PL- Consultation- Conservation Officer response

AB/34/26/PL

Address: 1 Flint Cottages Mount Pleasant Arundel BN18 9BD

Proposal: Alterations to rear first floor fenestration, replacement of all windows with white UPVC flush casements, replacement of external doors and replacement of existing balustrade to roof terrace (resubmission following AB/27/26/PL).

Drawing Name
Ground and First Floor Plans -
Proposed

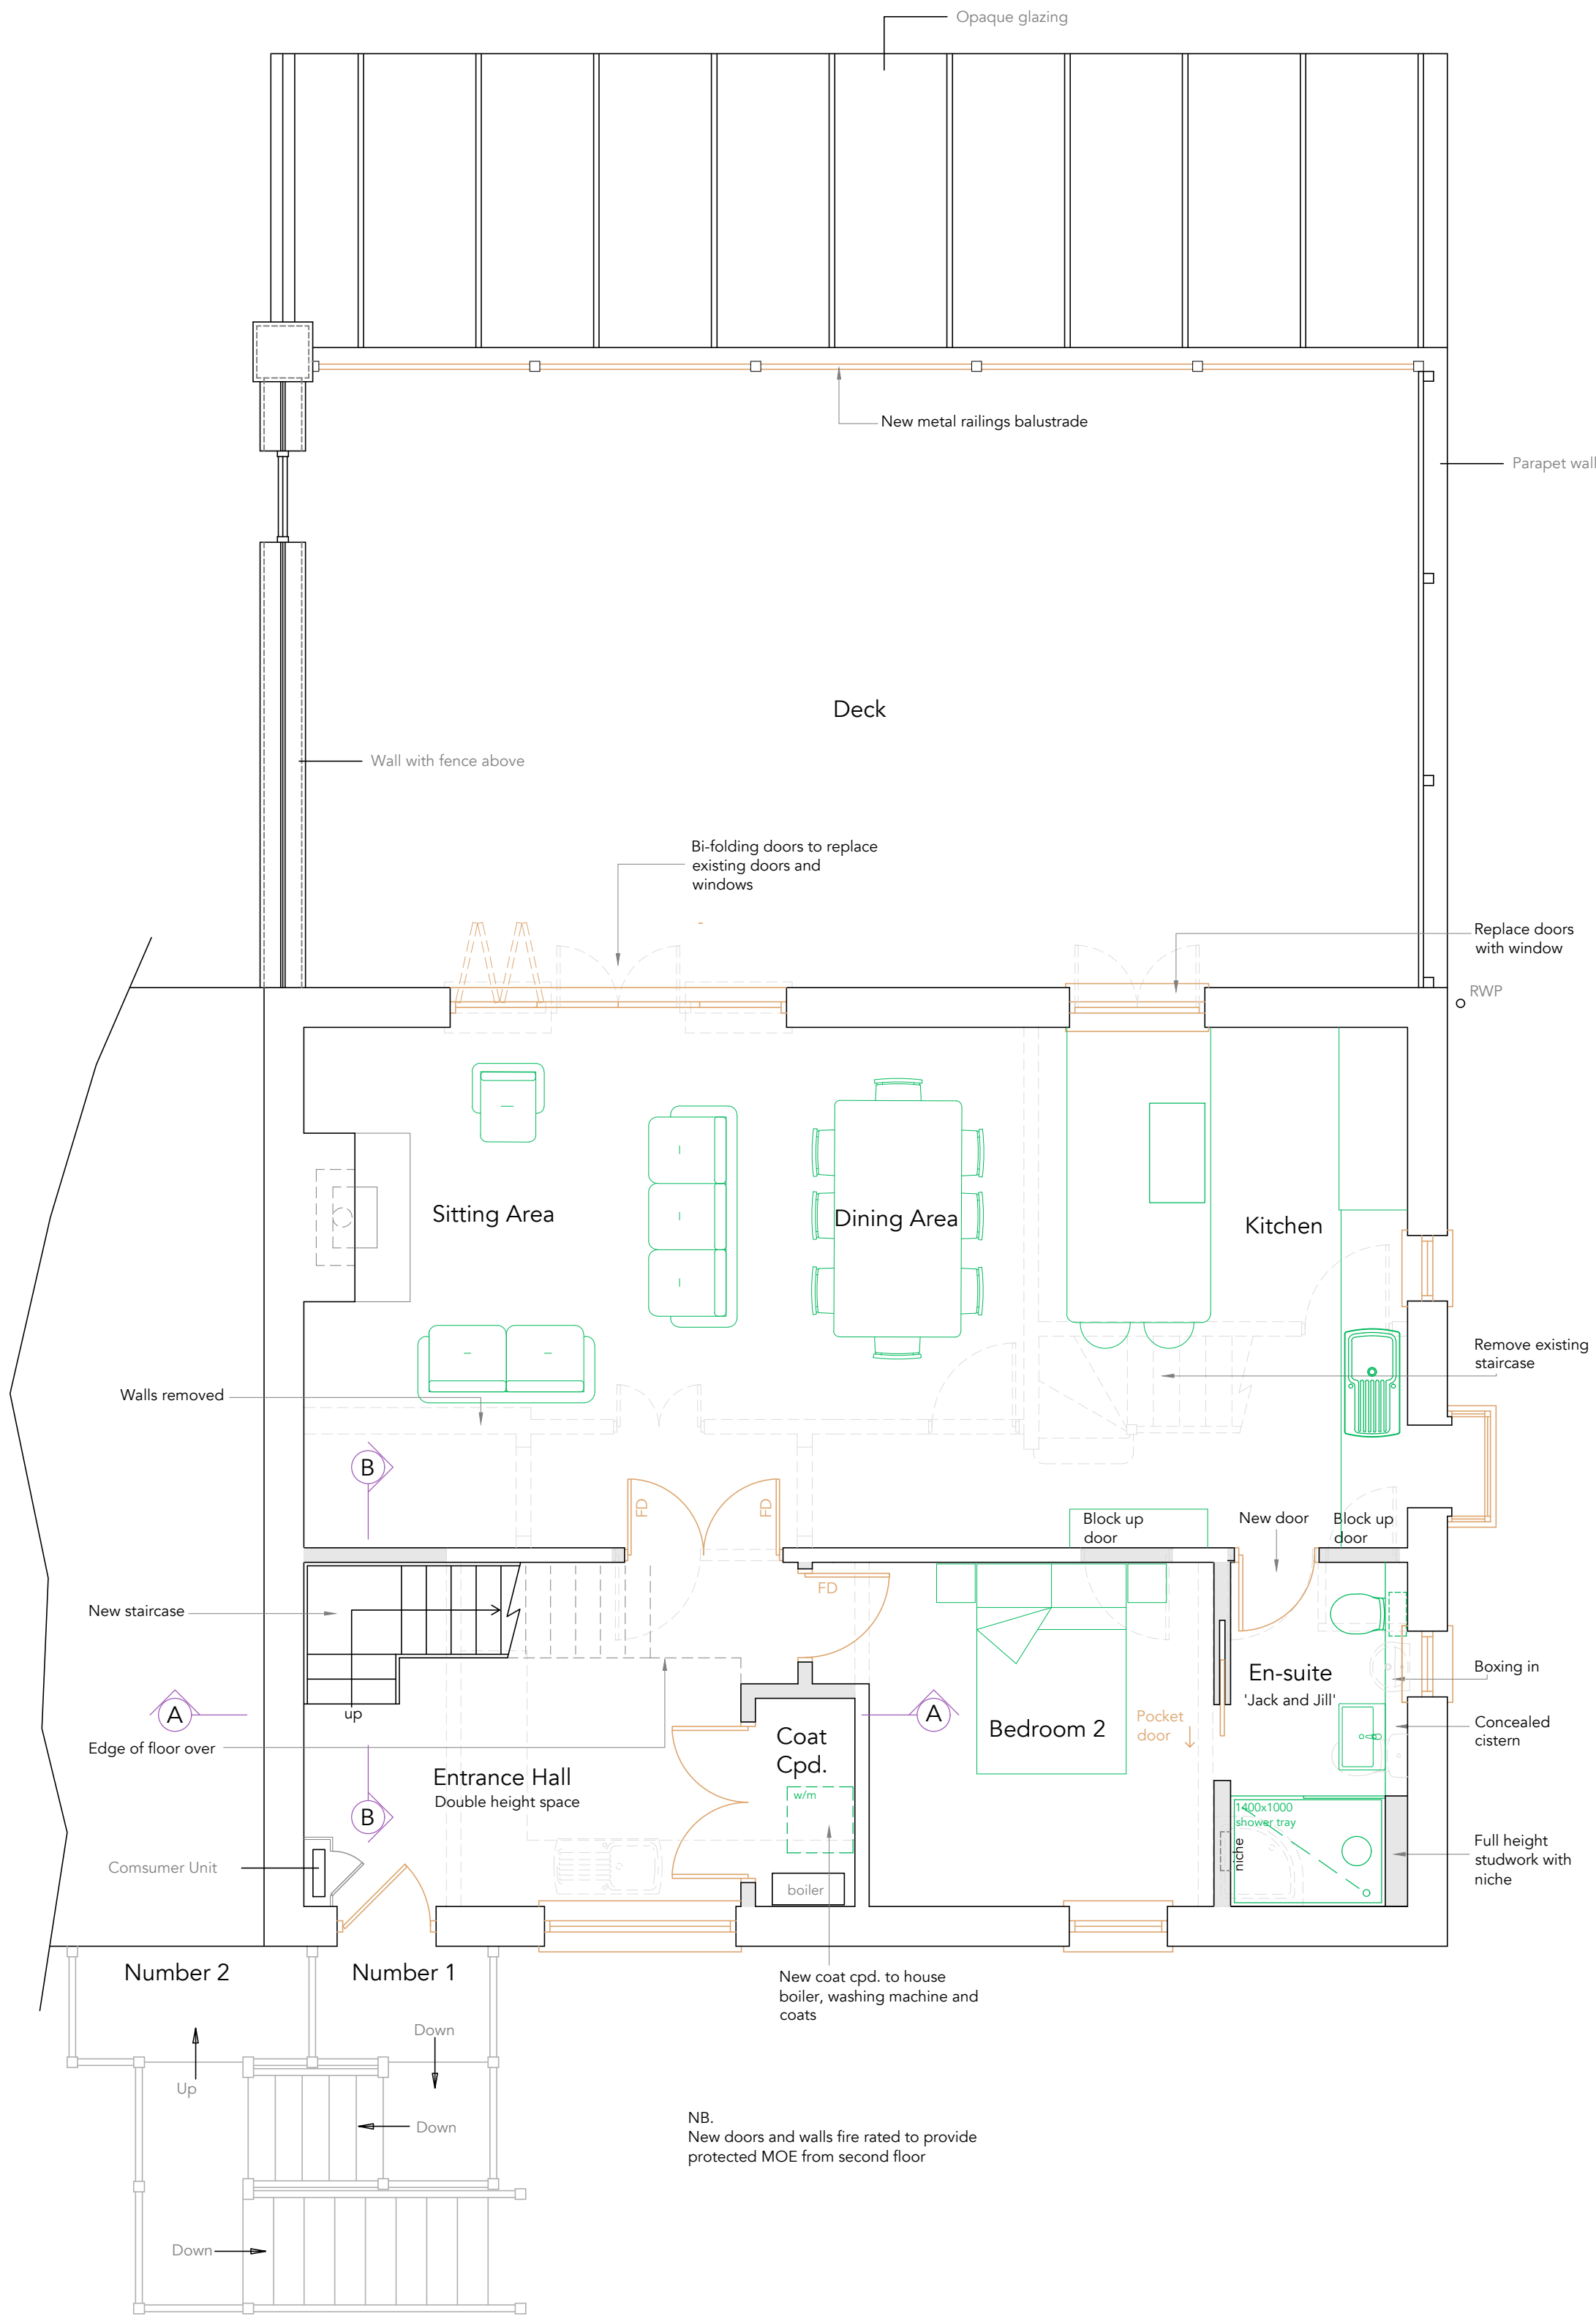
This application is a revision to a previously submitted scheme. It is clear that my earlier concerns have been taken into consideration and, as a result, the proposal has been improved. I note that the revised scheme includes new metal railings along the rear boundary. Following discussions with the case officer, additional information has been provided confirming that the railings will be of a simple design. This would be acceptable in this location and would preserve the character and appearance of the conservation area.
